DEVELOPMENT REVIEW BOARD  
SUPPLEMENTAL SUBMITTAL

PROJECT NO. PR-2021-005411

Application No. SI-2021-00760

**RE: AUTONATION - SITE PLAN  
DRB PROJECT NUMBER – 2021-005411**

BUILDING AREA: BUILDING : 18645 SF

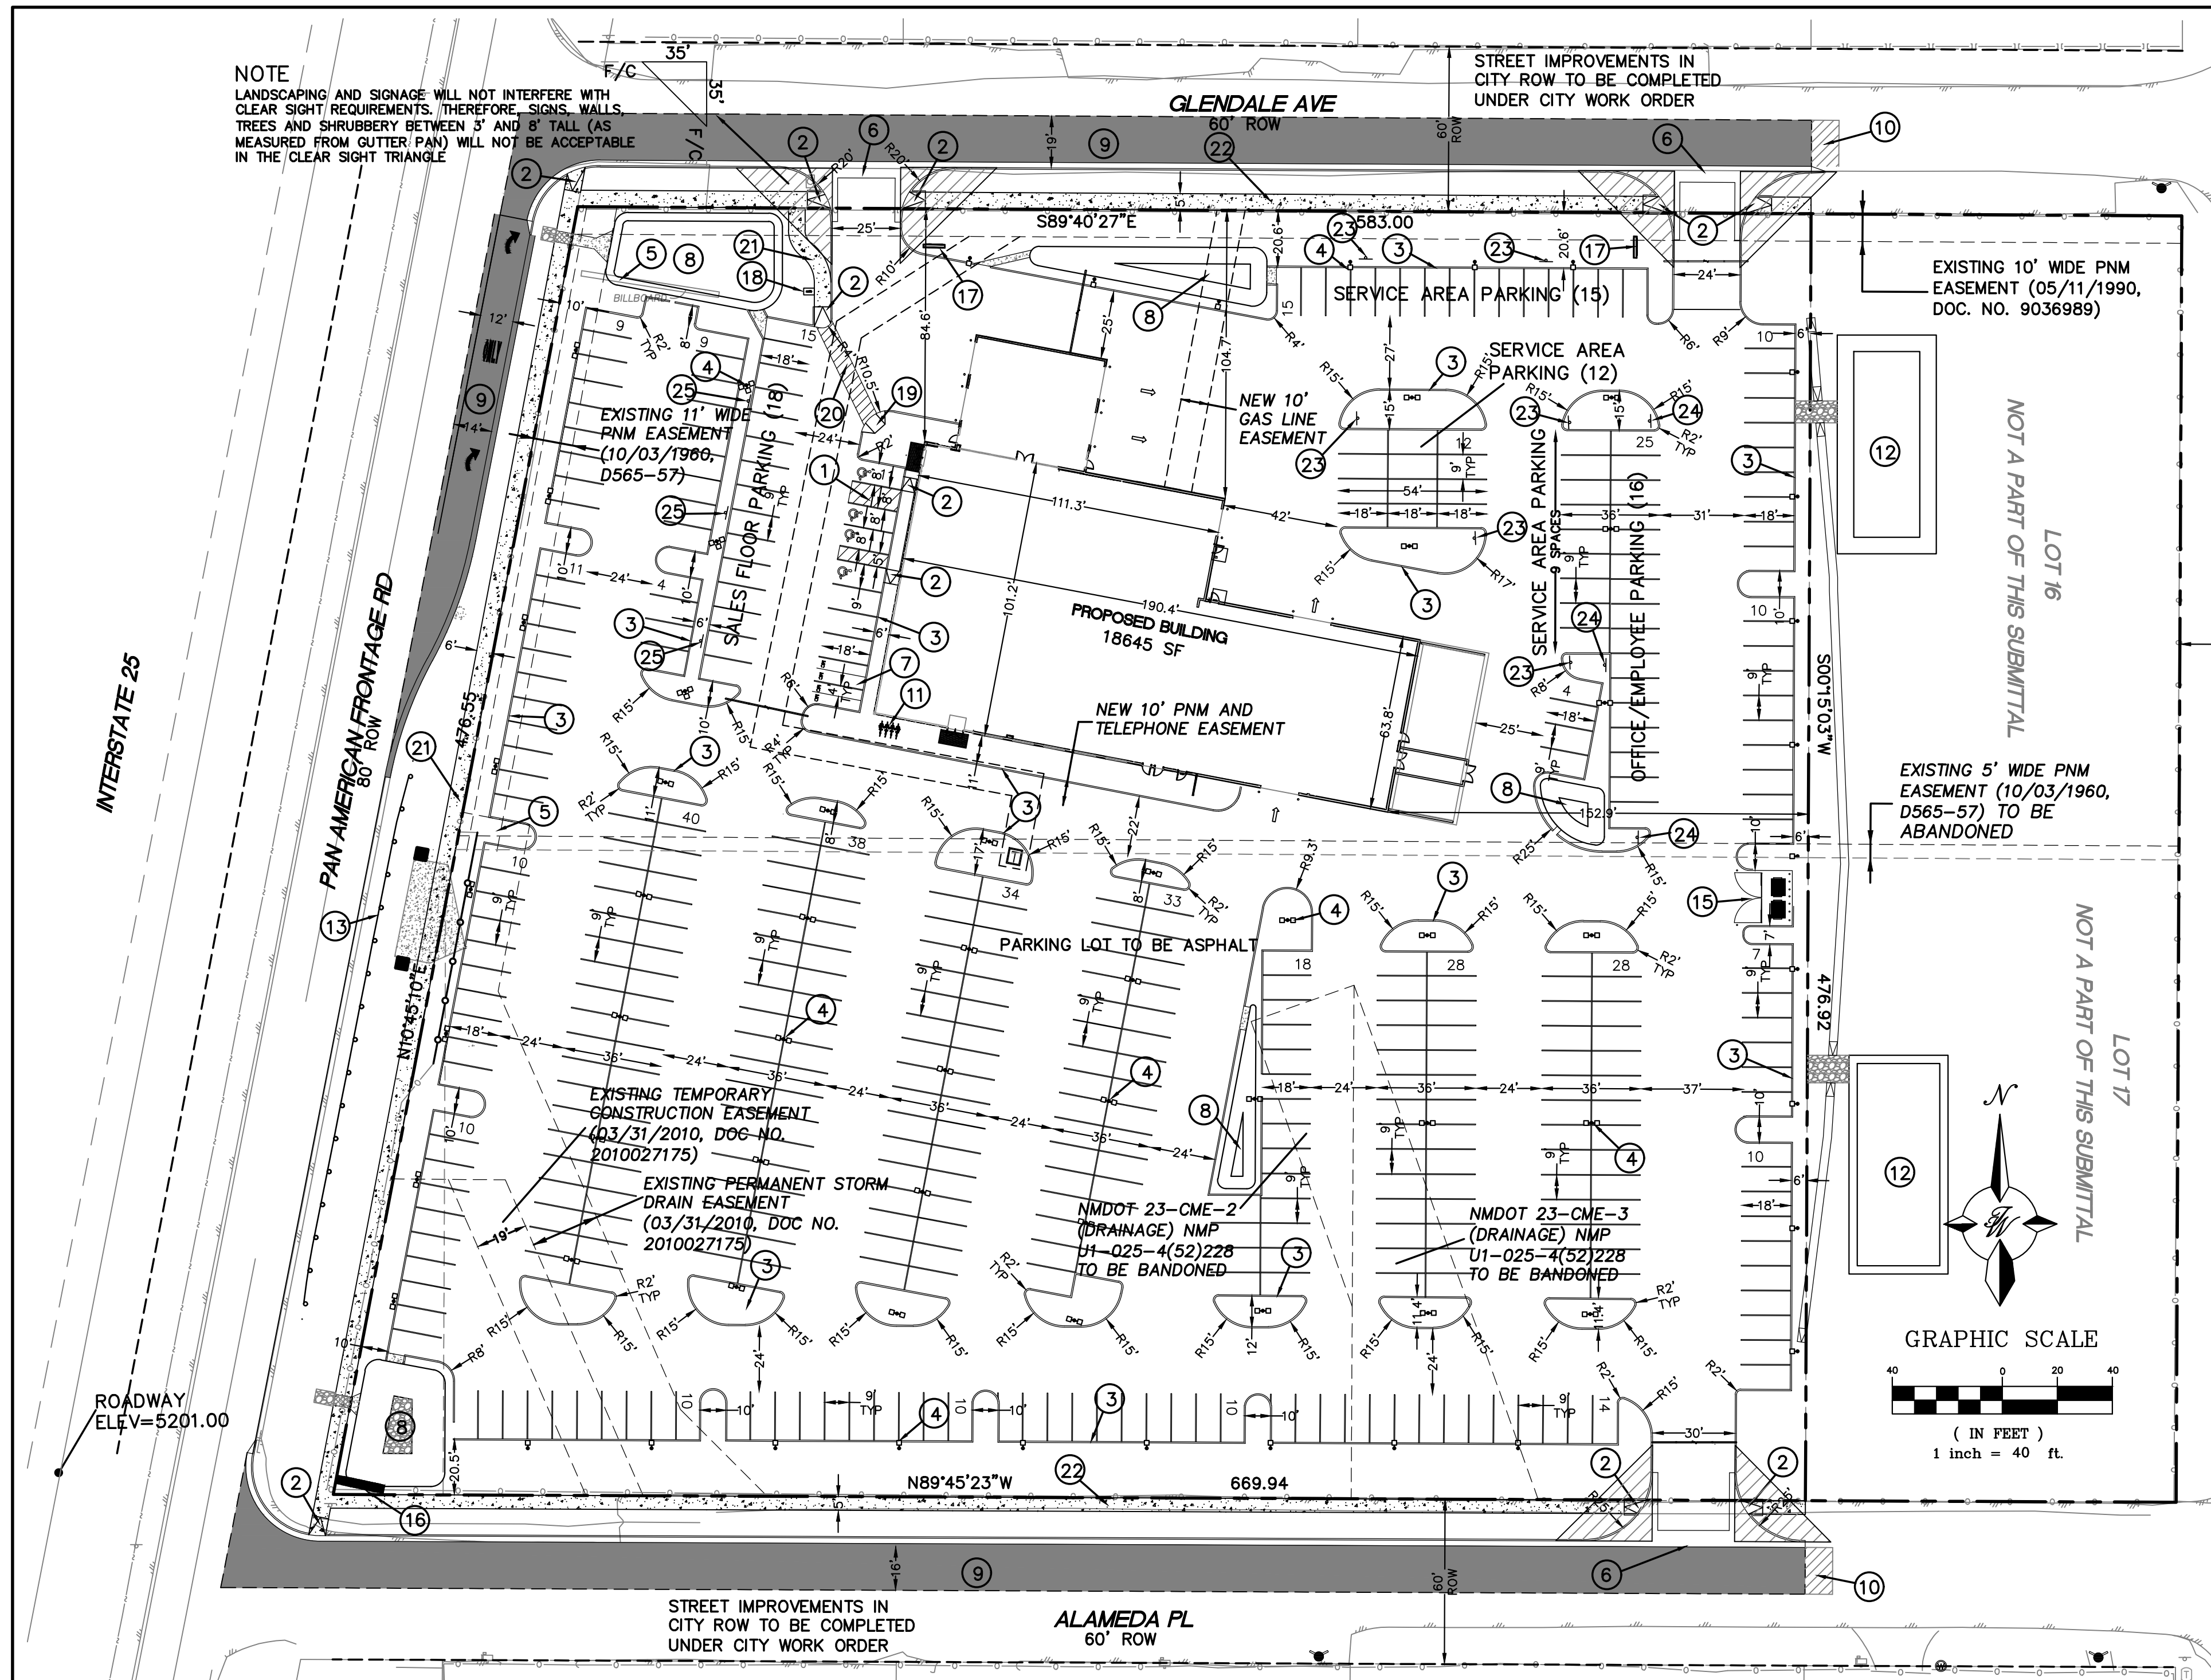
1. The site plan/grading plan call-outs for the sidewalk width do not match what is shown on the infrastructure list for Glendale and the frontage road.

4. Move monument sign out of clear sight triangle.  
**The signs are not located in the clear sight triangle.**
5. A 6-foot ADA path is required between handicapped spaces and main door entrance. Label pathway as 6 feet and label door entrance.

**The dimension and the keyed note were changed to reflect the width of 5'.**
2. Show signage for designated parking (service/employee parking).  
**Signs were added to the Site Plan and details provided on Sheet DET-1.**

**The sidewalk between the ADA parking spaces and the building was changed to be 6' wide.**
